SSD 6010 - One Residential Building (Student Accommodation) within Darling Drive Plot

Submission by:

Judith Kavanagh and Paul Dexter

28 July 2013

SHADOW DIAGRAMS: PERSPECTIVE, SHOWING THE PEAK, WINTER SOLSTICE

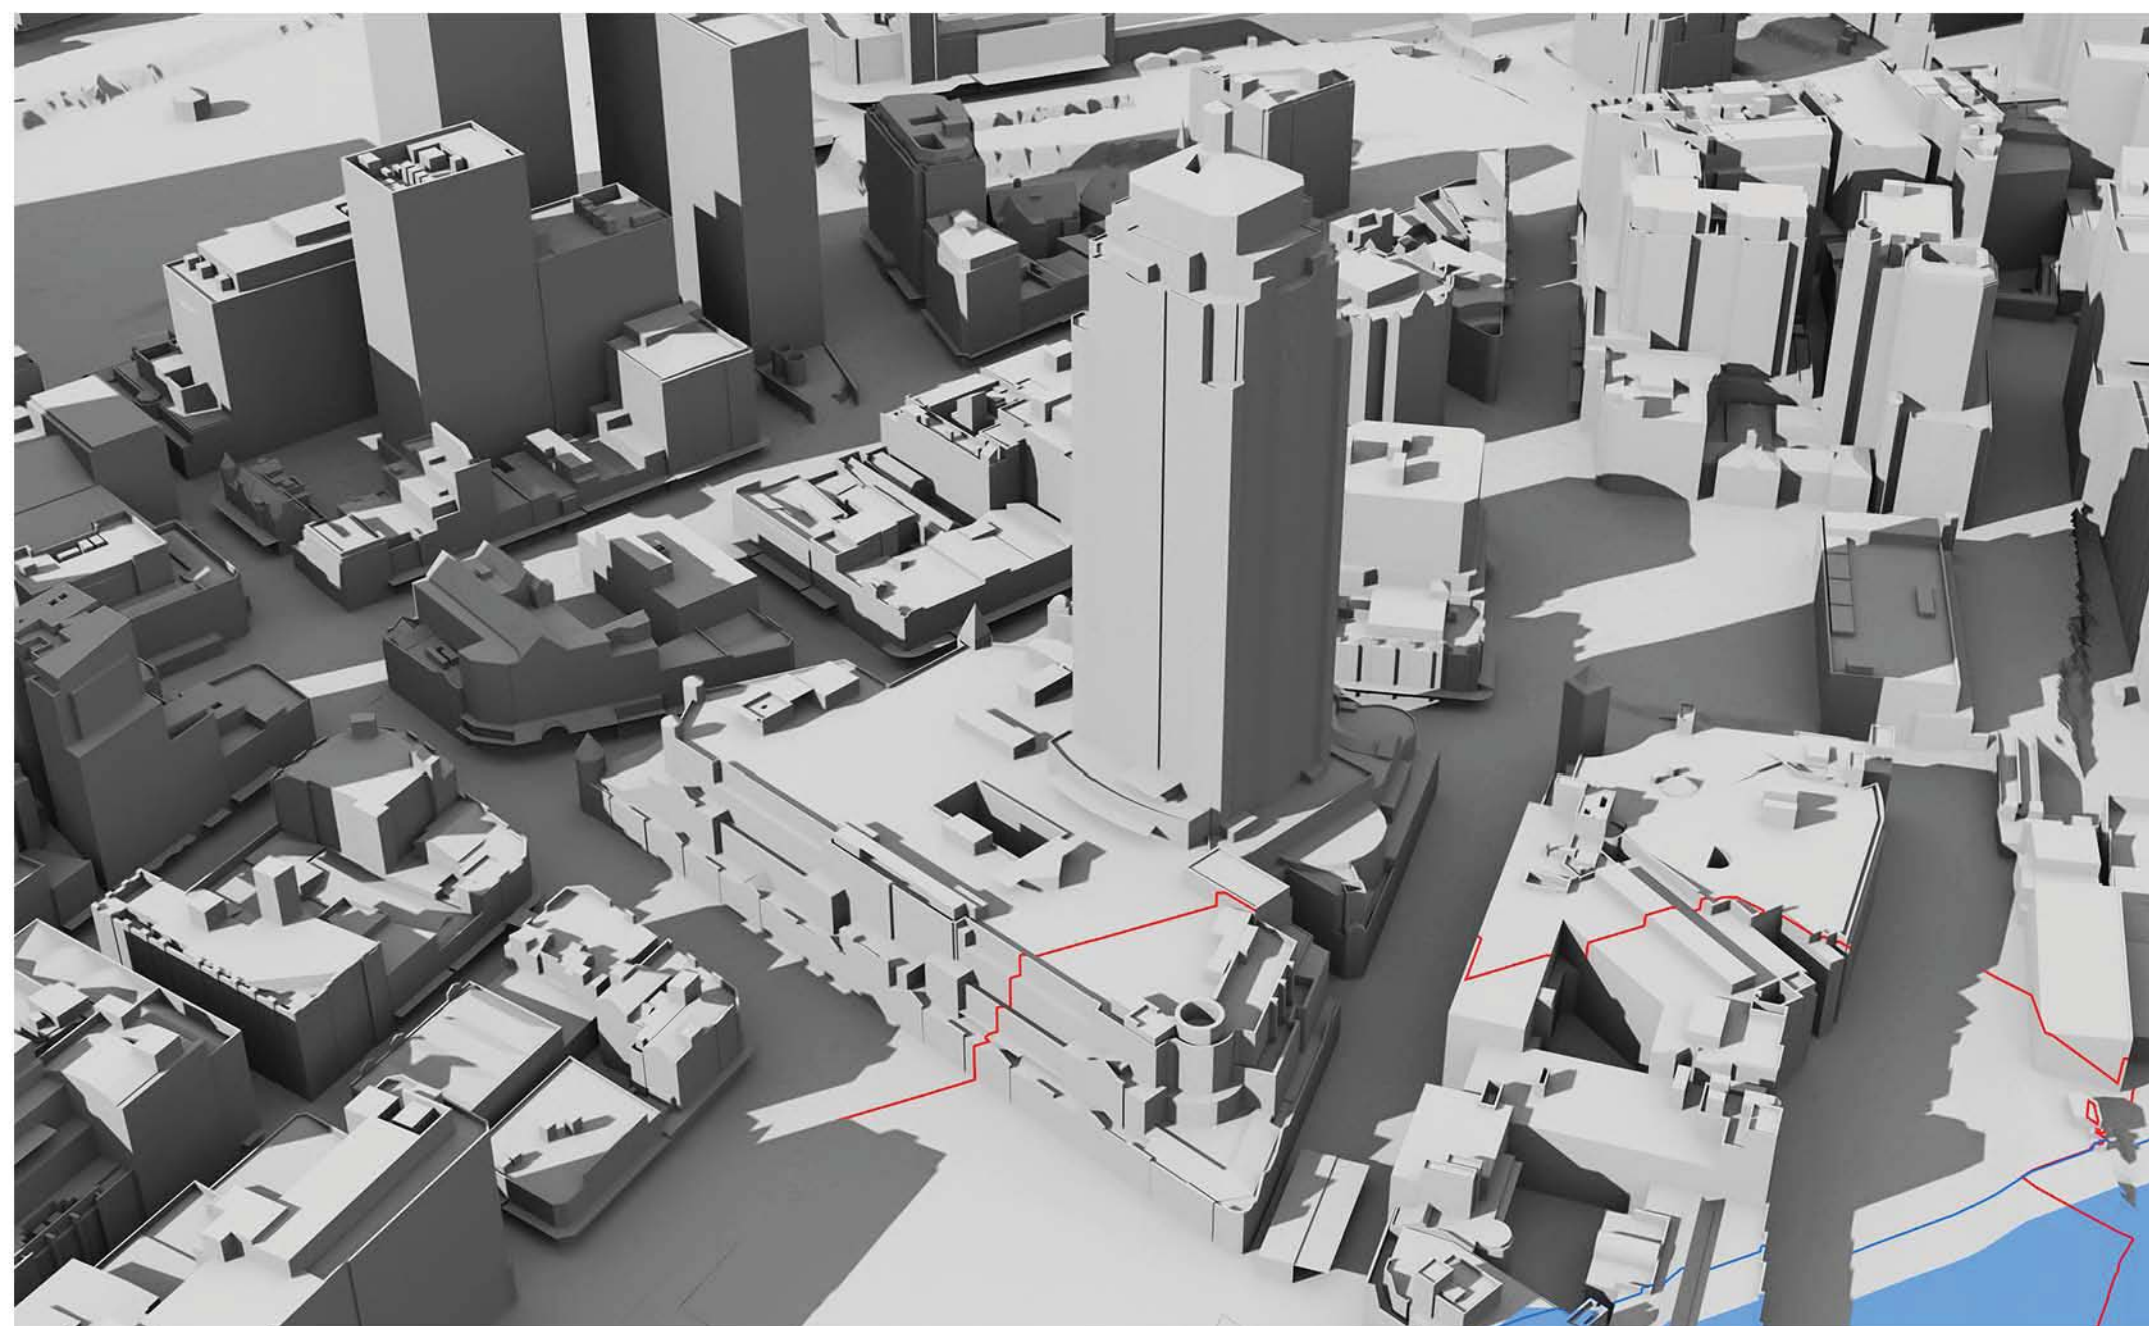
At 9am, 10am and 11am the west façade is totally in shadow due to other parts of The Peak building itself.

At 12pm there is still substantial existing shadowing on the west façade caused by the irregular shape of the west facade.

At 1pm the existing shadowing has been substantially removed, but not totally removed.

It can be concluded that some single aspect apartments on the west façade and some south-west dual aspect corner apartments currently receive less than 2 hours direct sunlight to habitable rooms and 50% of the private open space between 9am and 3pm on 21 June.

By 2pm the existing shadowing has been totally removed, but that is too late to achieve two hours of direct sunlight before 3pm.

At 9am, 10am and 11am the west façade is totally in shadow due to other parts of The Peak building itself.

At 12pm there is still substantial existing shadowing on the west façade caused by the irregular shape of the west facade.

At 1pm the existing shadowing has been substantially, although not entirely, removed. However, overshadowing of lower levels of the west façade by the concept proposal parameter plan shadows for the N,NE and SE plots has already started.

By 2pm the existing shadowing has been totally removed. However, overshadowing of the west façade by the SSDA4 and SSDA5 buildings has appeared and risen further up the west façade than the concept proposal parameter plan shadows for the N,NE and SE plots, which is still present.

At 3pm, the proponent states correctly that 45-45% of the western façade is overshadowed by the SSDA4 and SSDA5 buildings.

It can be concluded that, as a result of combination of the proposed development with existing shadowing of the west façade, some single aspect apartments on the west façade and the south-west dual aspect corner apartments which currently receive less than 2 hours direct sunlight to habitable rooms and 50% of the private open space between 9am and 3pm on 21 June will suffer additional overshadowing. It is beyond our skills to count the number of such apartments. We note that the proponent has made no attempt to do so.

Rather than counting the number of units which will not meet the DCP guidelines, the proponent attempts to trade-off direct sunlight at 4pm for lack of direct sunlight during the period 9am to 3pm. There is no provision in the DCP guidelines for such a trade-off.
